From: Wiswell Parish Council <parish.council@wiswell.plus.com>
Sent: 25 May 2016 12:13
To: planning
Subject: FAO Adrian Dowd: Consultation on planning application 3/2016/0366 Freemasons Arms, Vicarage Fold, Wiswell BB7 9DF

Planning Application: 3/2016/0366

The Freemasons Arms, Vicarage Fold, Wiswell, BB7 9DF

Single storey extension to Freemasons kitchen and change of use of 4 and 6 Vicarage Fold from 2 dwellings to 4 letting bedrooms.

PROPOSED ELEVATIONS

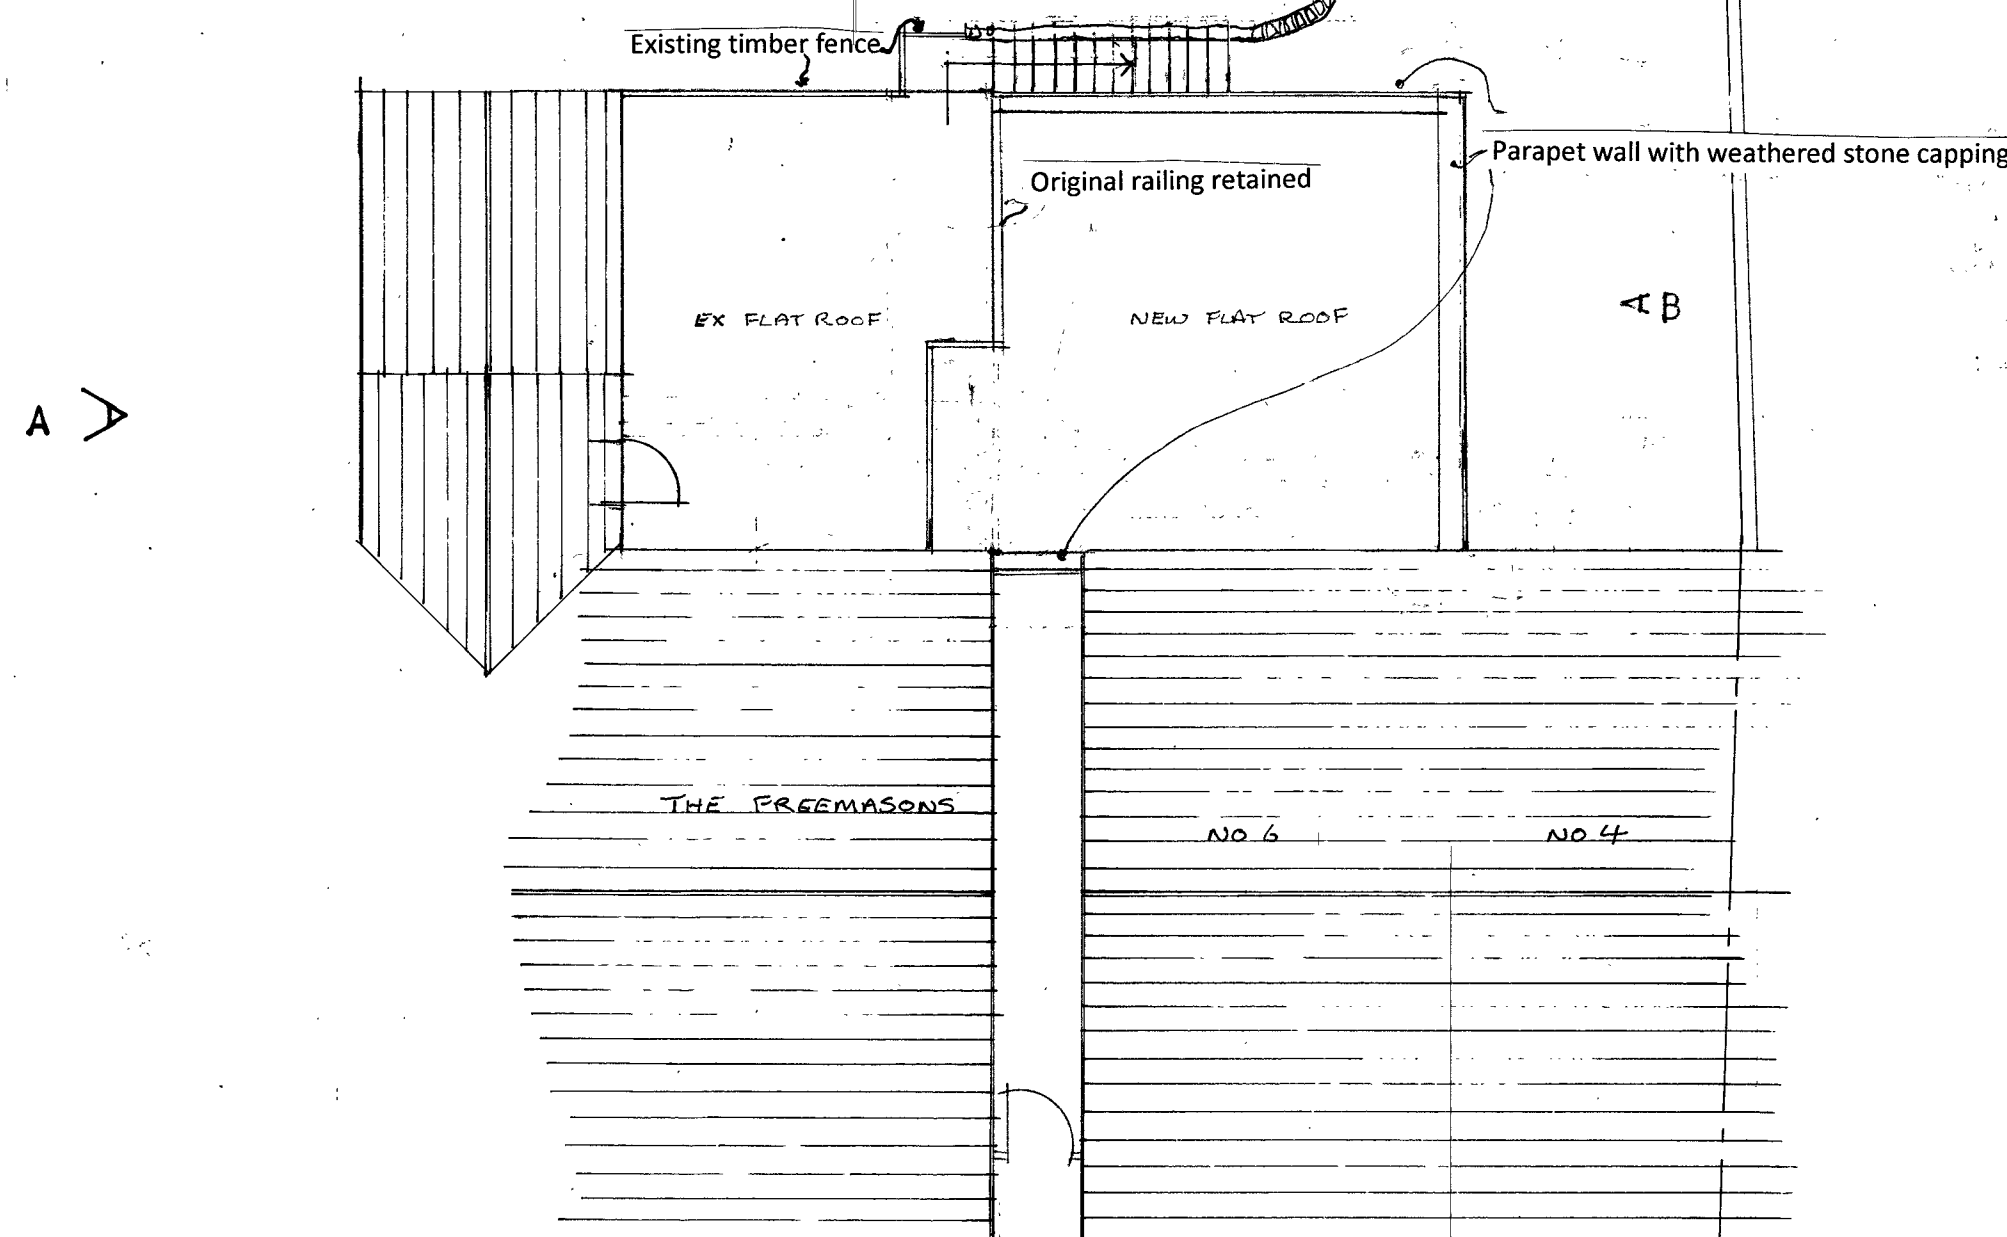
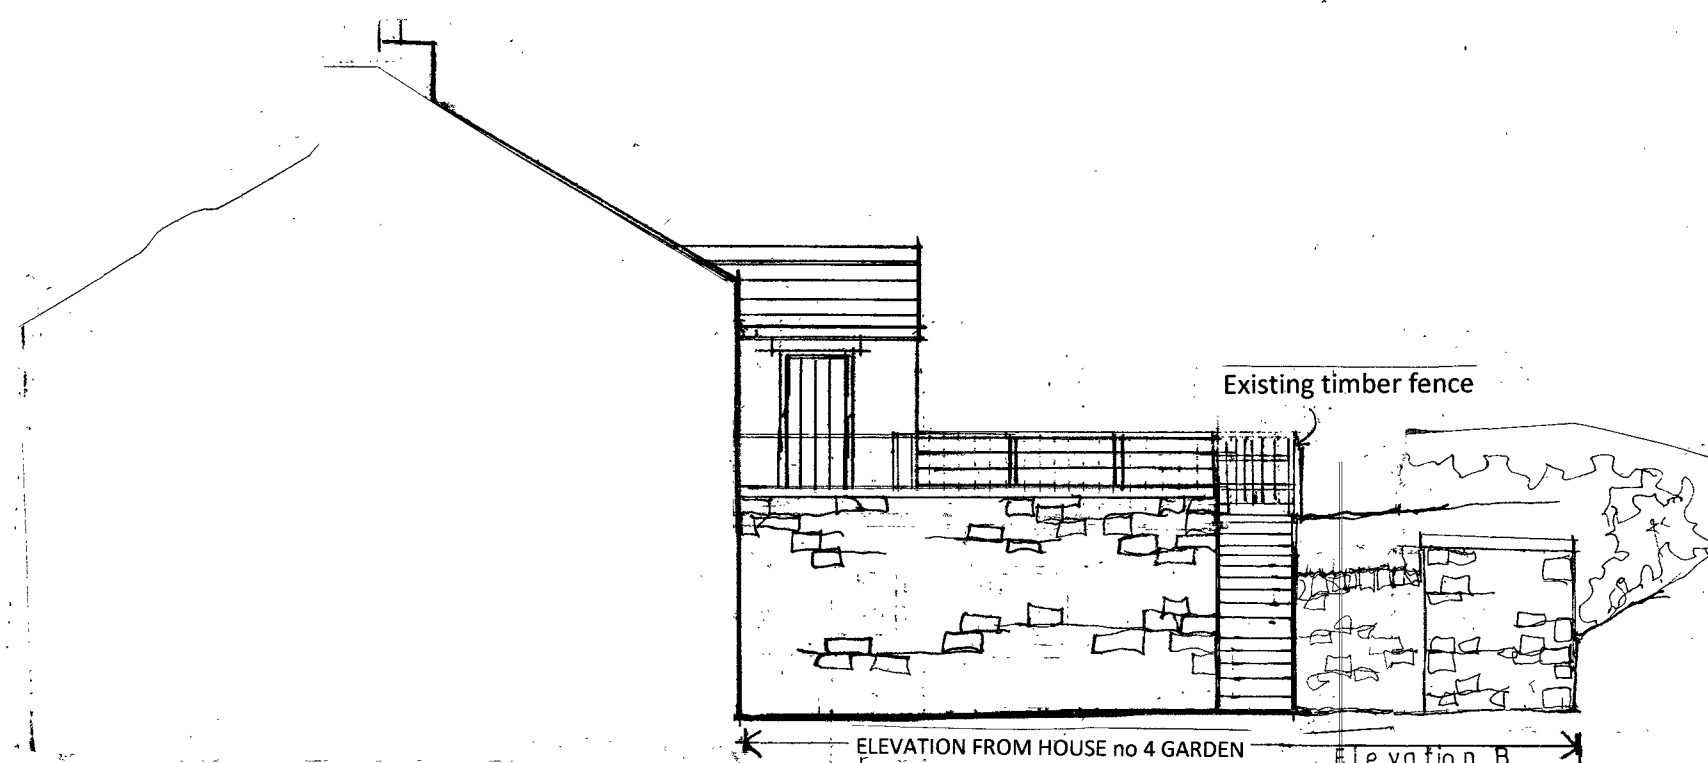
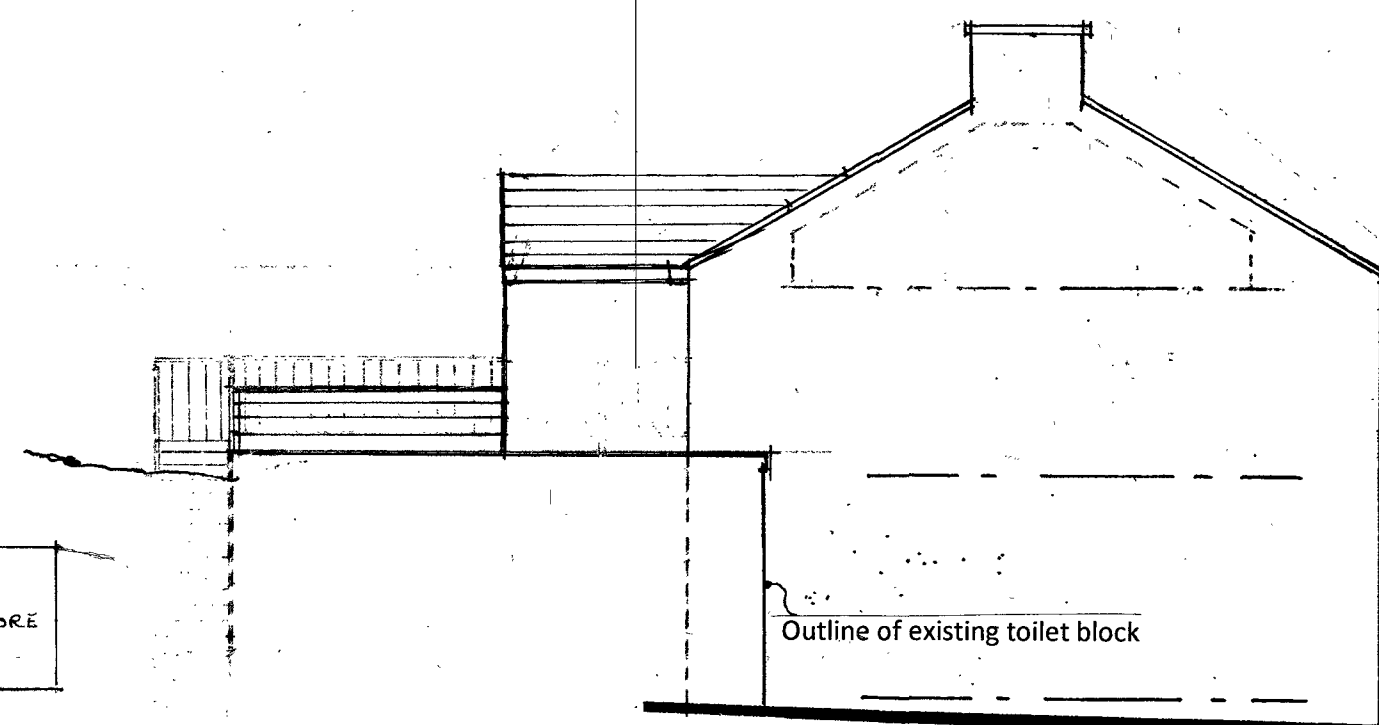
4. The plans are not detailed enough to show the effect of the proposals on the rear of 4 Vicarage Fold, including the emergency fire exit.
5. The proposals will result in an increase in overlooking and noise disturbance for neighbours and a loss of their residential amenity. It is noted that residents of Chapel Fold have not been consulted on this application even though they face the rear of The Freemasons and are exposed to the noise and smell of the kitchen operation.

6. There are no details of the kitchen extraction system on the new extension. The current extraction system gives rise to nuisance noise and smells and the new extension has the potential to increase the nuisance to surrounding residents, if inadequate. If no new system is to be installed, the current system should be checked for its capability to deal with an increase in kitchen size.

Drawing Title
PROPOSED PLANS

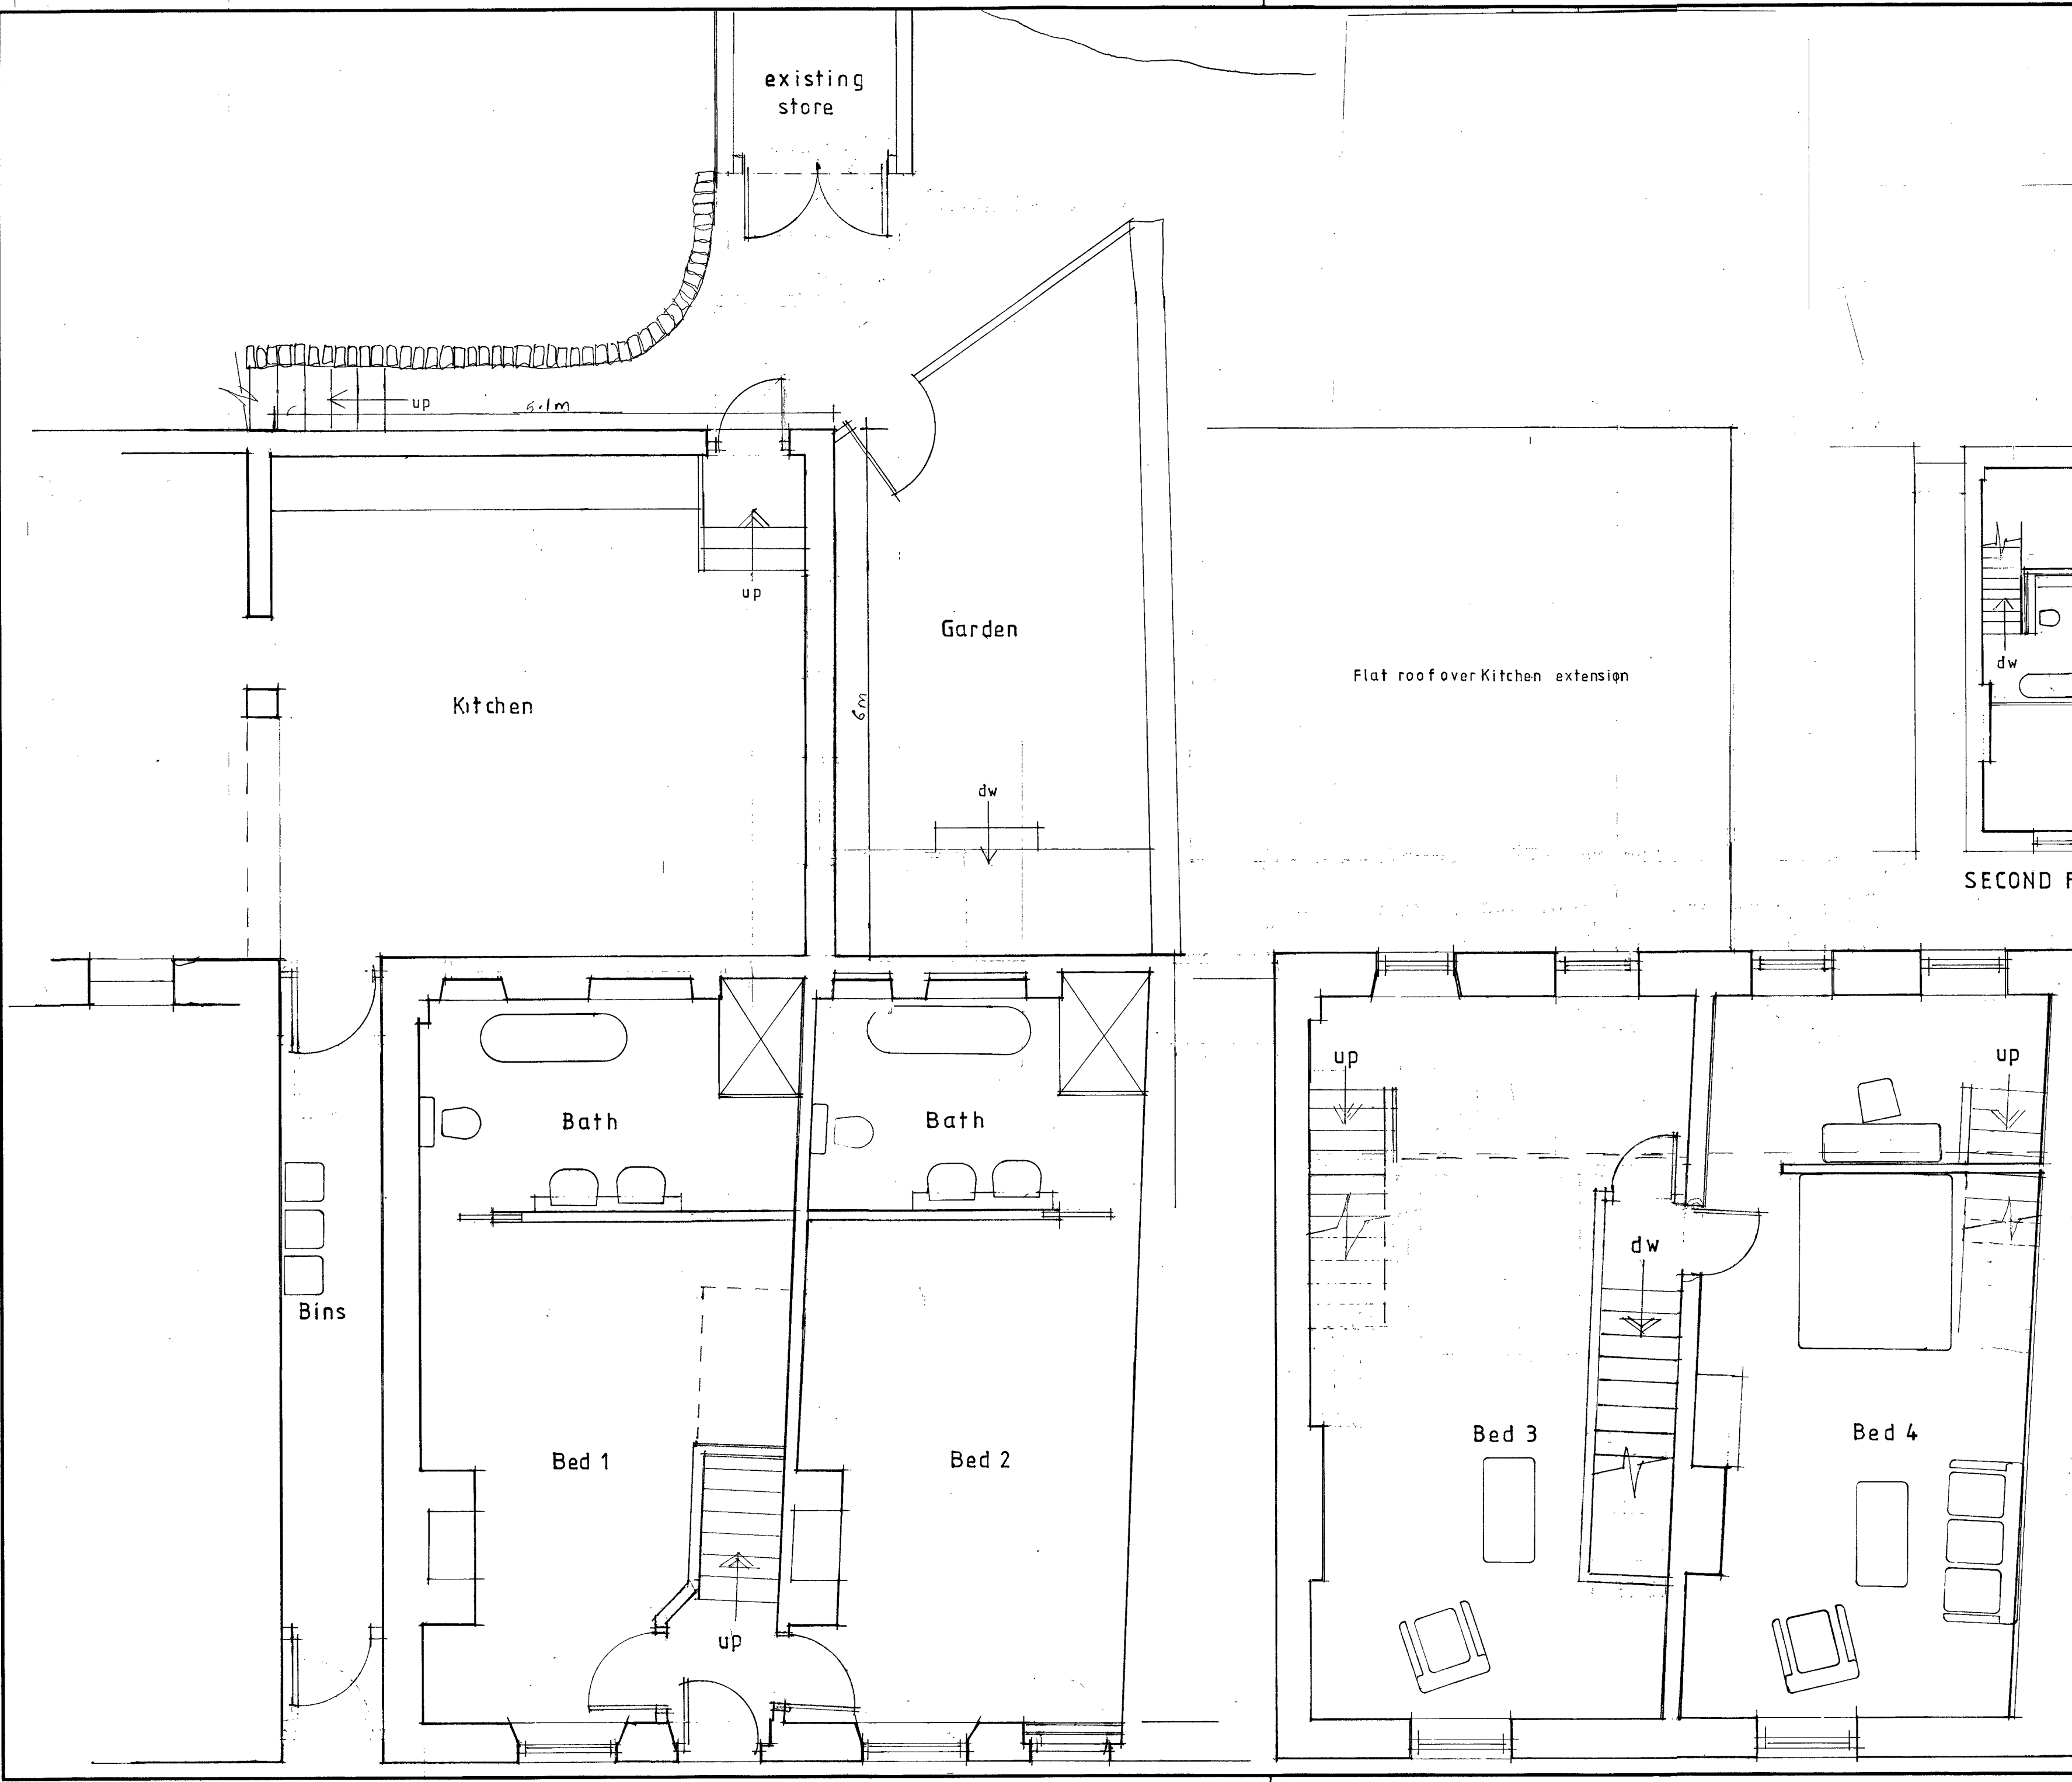
7. There is inadequate provision for storage and waste removal for commercial premises which includes a public house, restaurant and hotel. The current capacity for waste disposal is 100% more than shown on the plans. Large bins are currently kept in the alcove at the side of the kitchen but they are too large to be placed in the narrow alleyway and still allow regular or emergency access for staff and deliveries.
